TOWN AND COUNTRY PLANNING ACT 1990 FULL

Reference: H06-0204-25 **Date of Decision:** 13th May 2025
Applicant: Mr E Harris
Hallgate House
Hallgate
Gedney
Spalding
PE12 0DA
Location: Blazegate Lutton Spalding
Description: Change of Use/Conversion and extensions of Brick Storage Barn to Residential

South Holland District Council hereby give notice that this application has been REFUSED for the above proposal for the following reason(s):

SITE PLAN

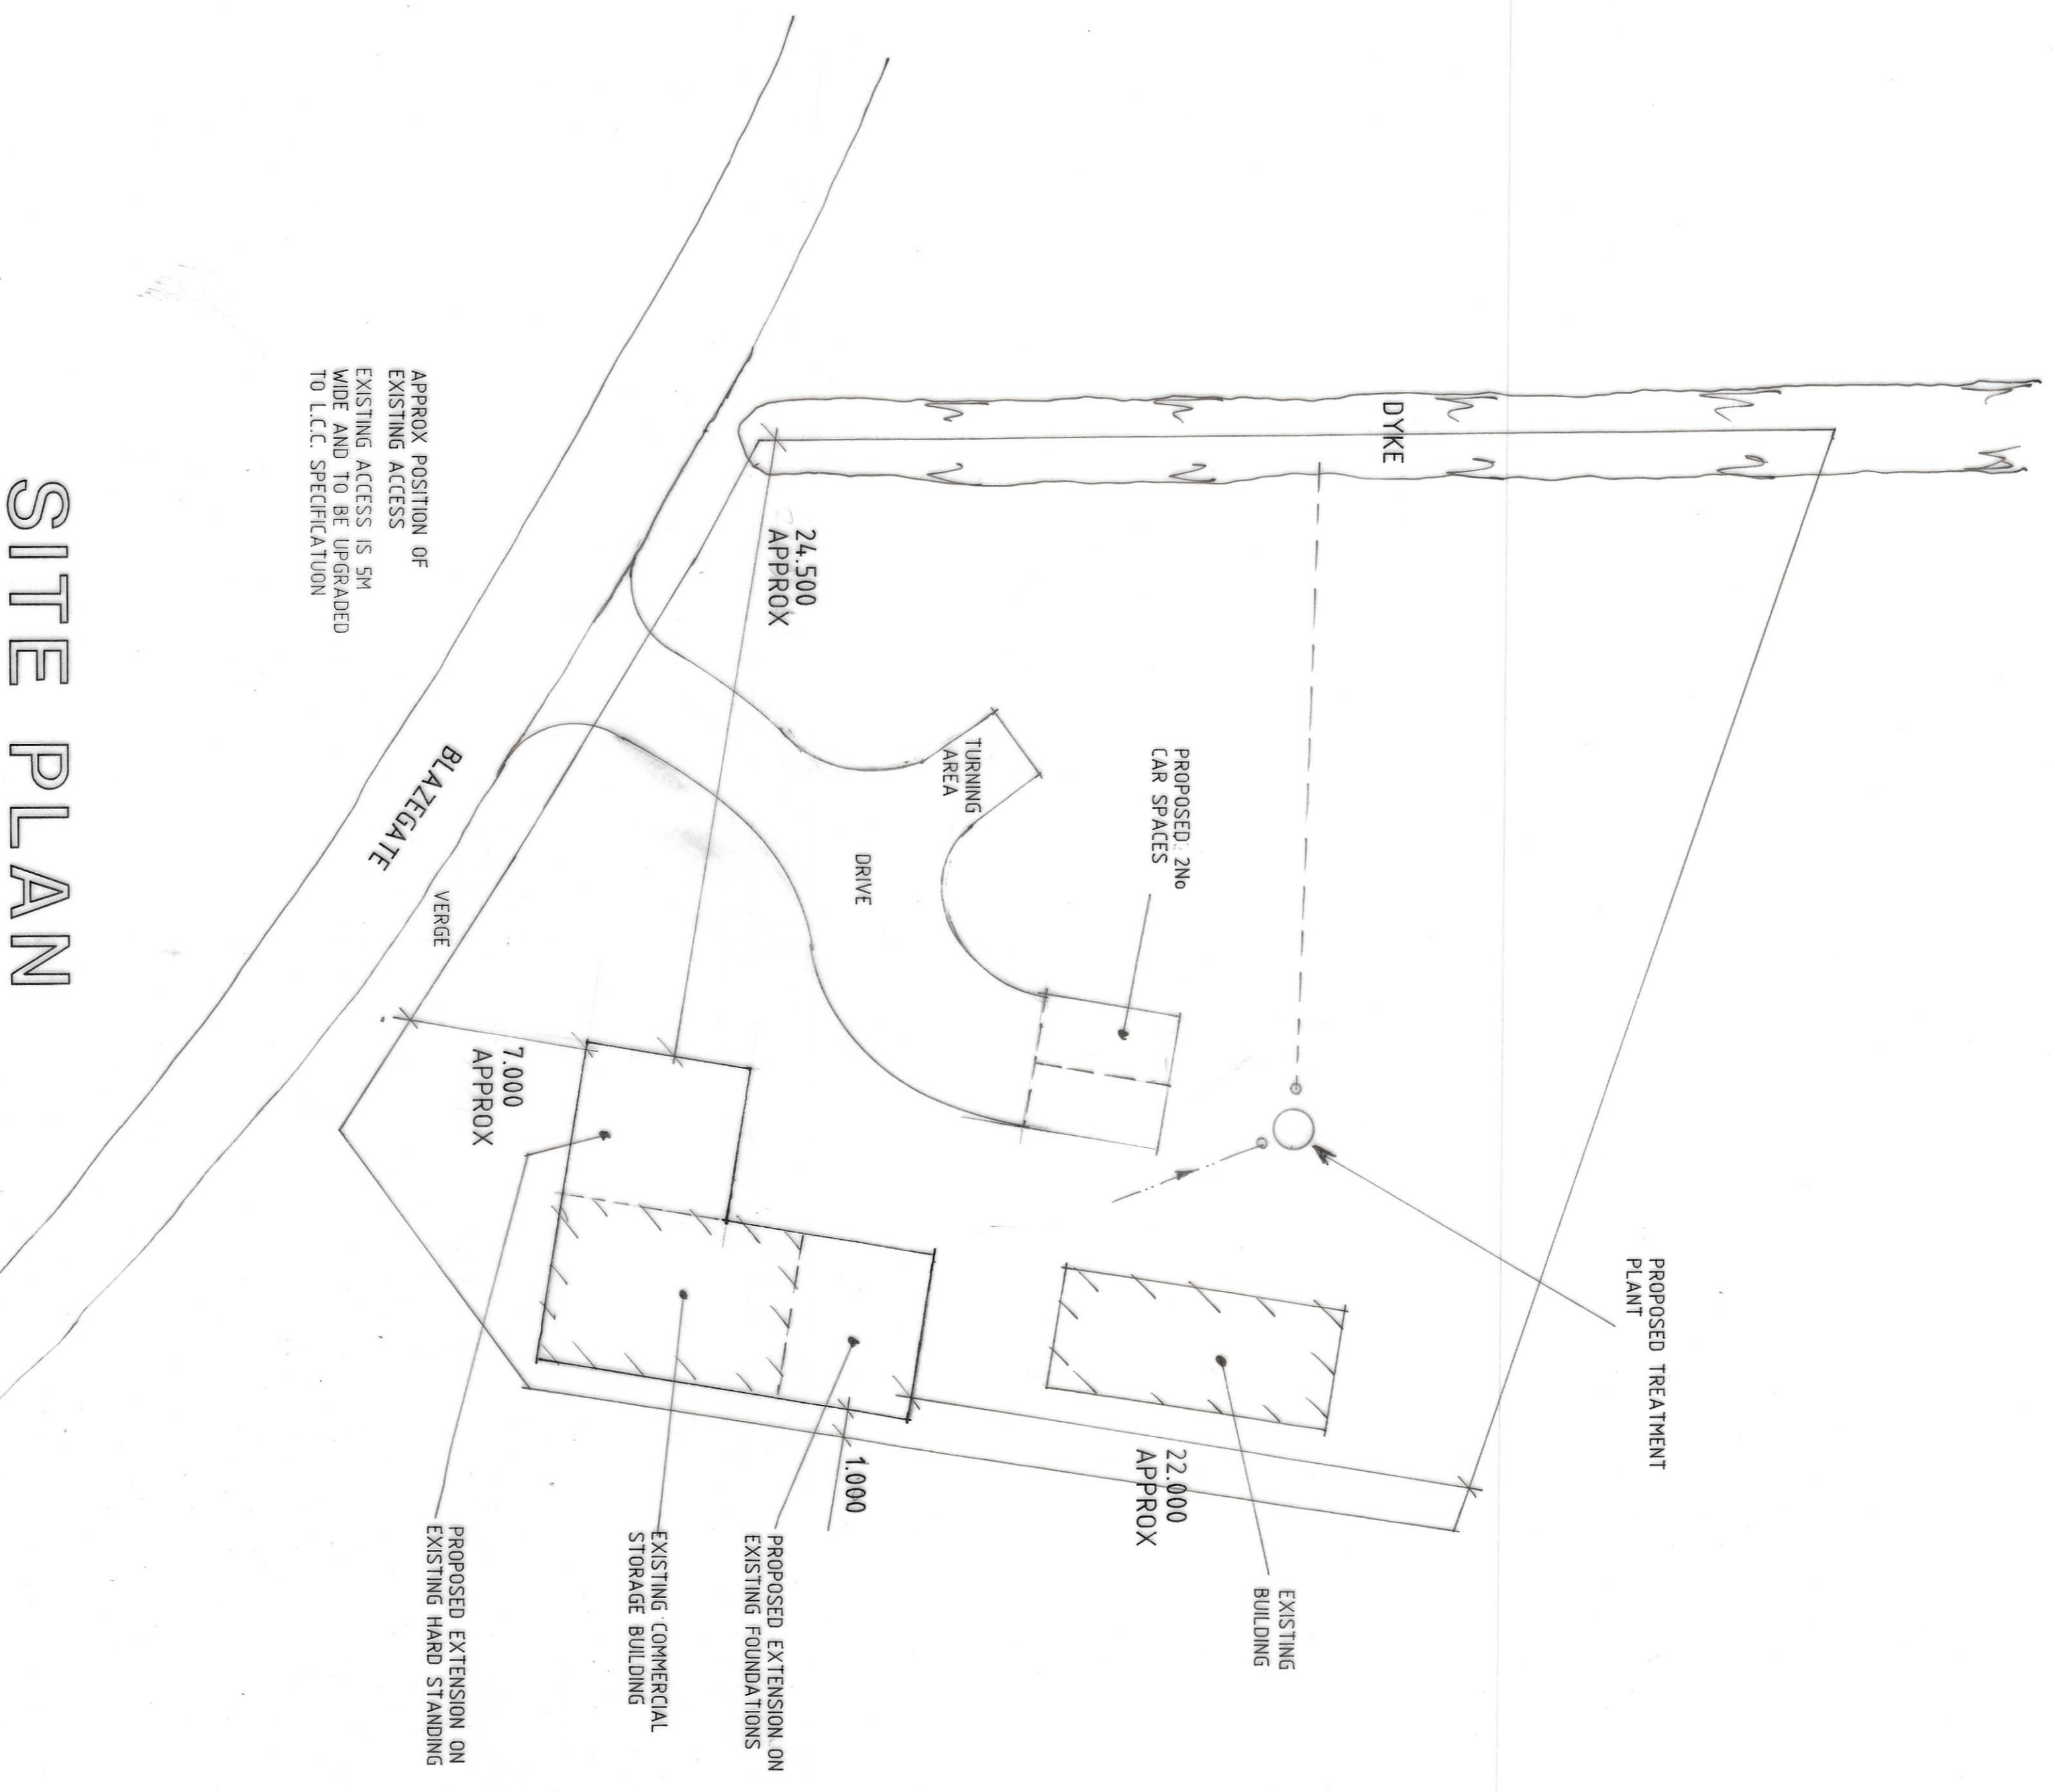
- 2 The site is located in Flood Zone 3 of the Environment Agency's Flood Maps. Within the South-East Lincolnshire Strategic Flood Risk Assessment the site is classified as "danger for most" with flood depths of up to 1 metre. Policy 4 of the South East Lincolnshire Local Plan, 2019, states "Change of use that would result in self-contained ground floor residential accommodation in areas of hazard rating 'danger for some', danger for most' and 'danger for all' will not be supported." As such, it is considered that, due to the significant flood risk on the site and the lack of suitable adaptation proposed, the occupants of the conversion would be at an undue risk of the impacts of flooding.

PLAN AS PROPOSED

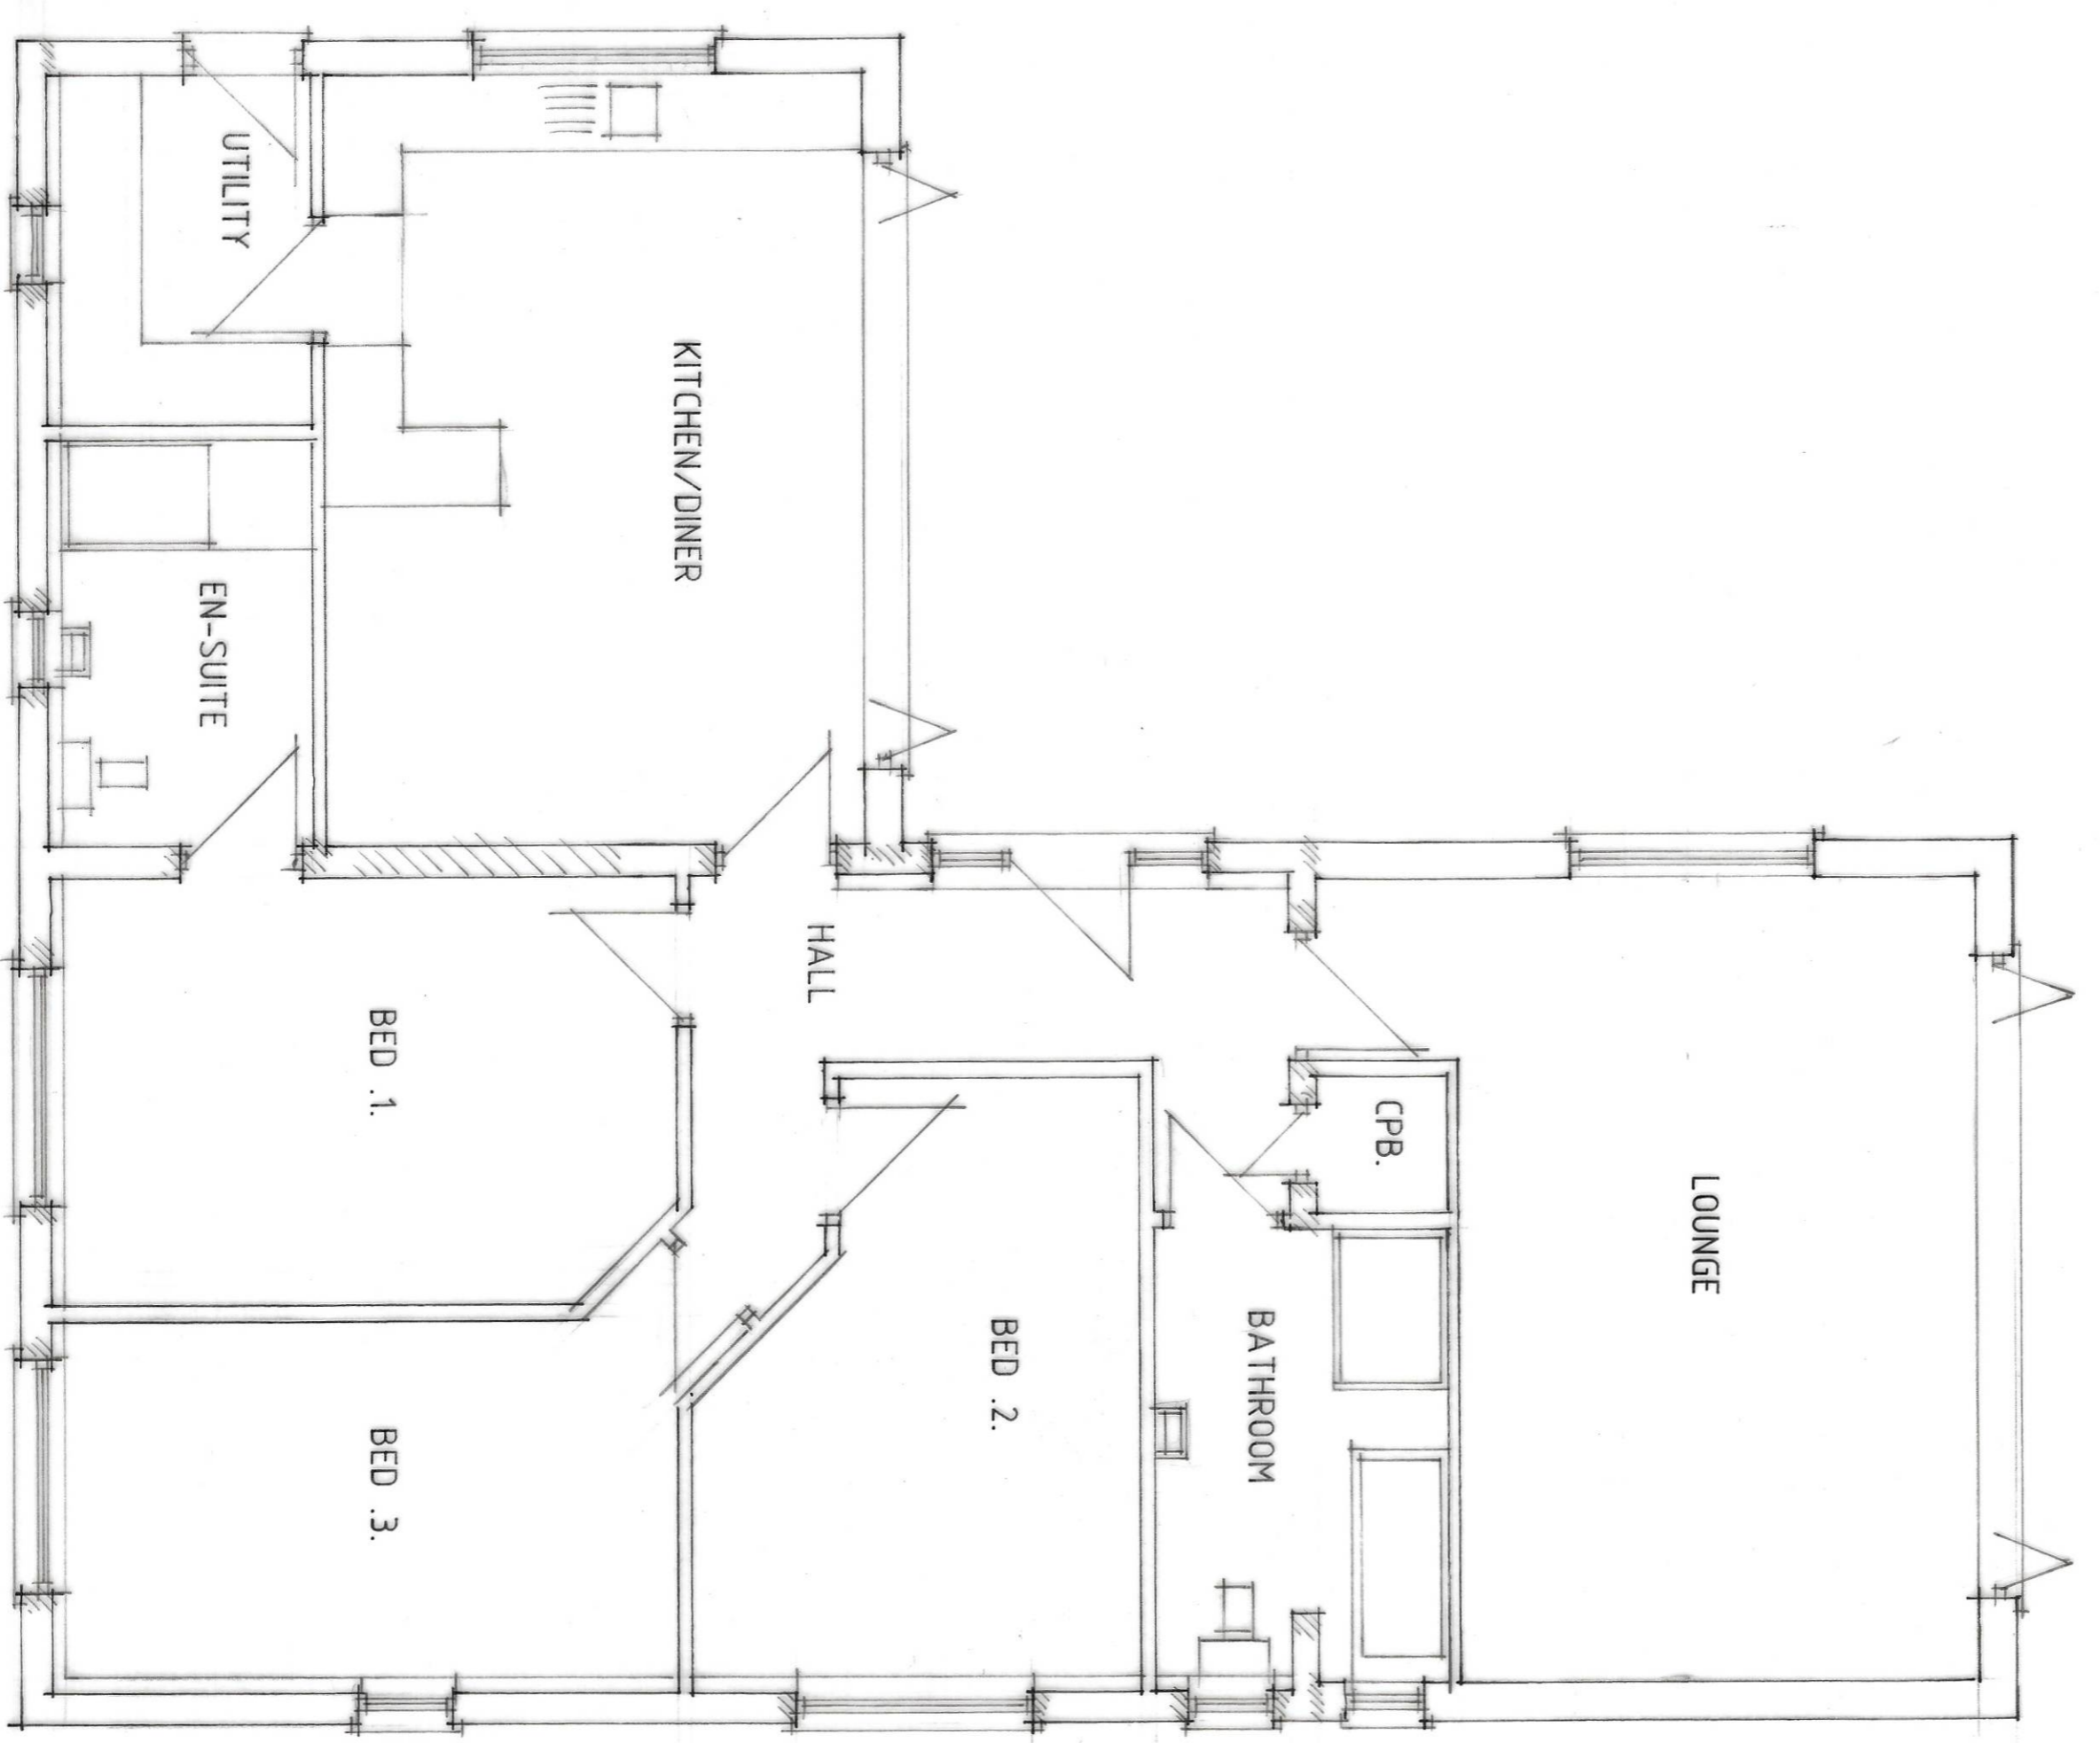
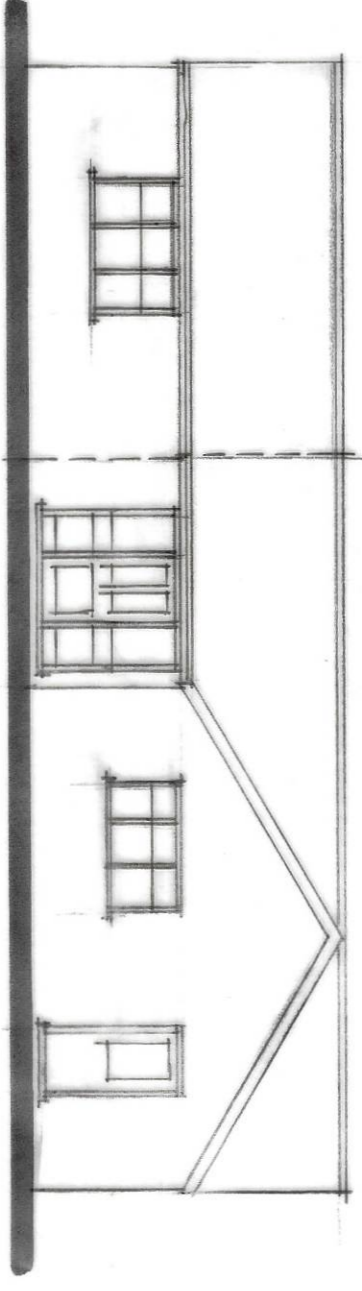
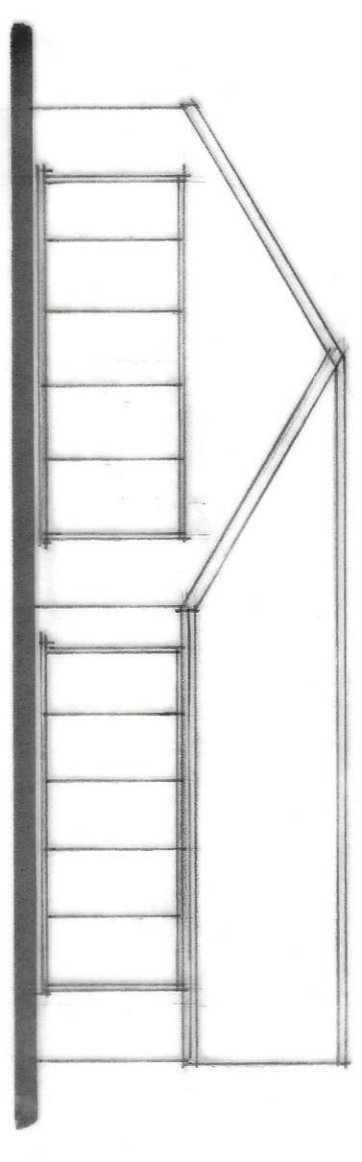
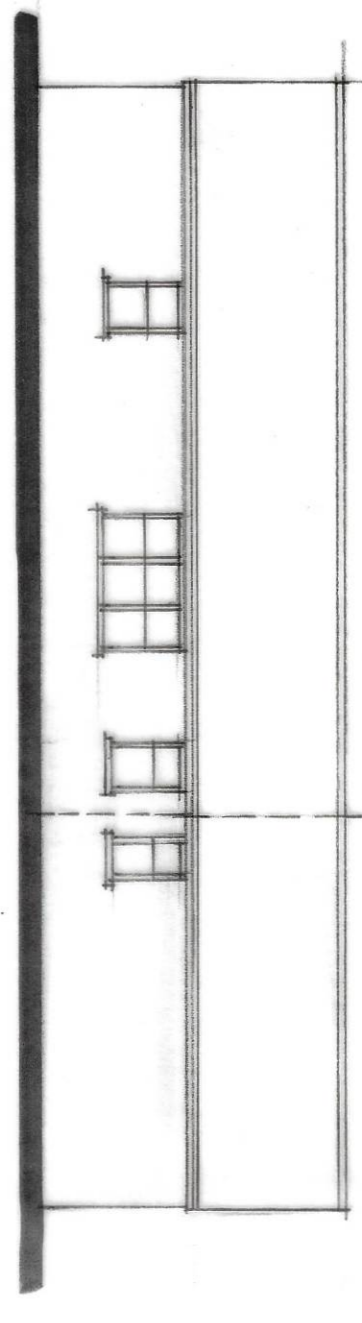
The extensions proposed would exceed the scale of the existing building, thereby representing a significant extension and alteration which would far exceed what could reasonably be expected under criterion 1 of Policy 23. Furthermore, the existing building itself is of no architectural or historic merit to justify its retention; therefore, failing to meet the principles of criterion 2 of Policy 23. While the proposed extensions may neaten the existing building to a certain extent, they would not enhance the building to such an extent as to carry significant weight in favour of the proposal, particularly in light of their disproportionate scale.
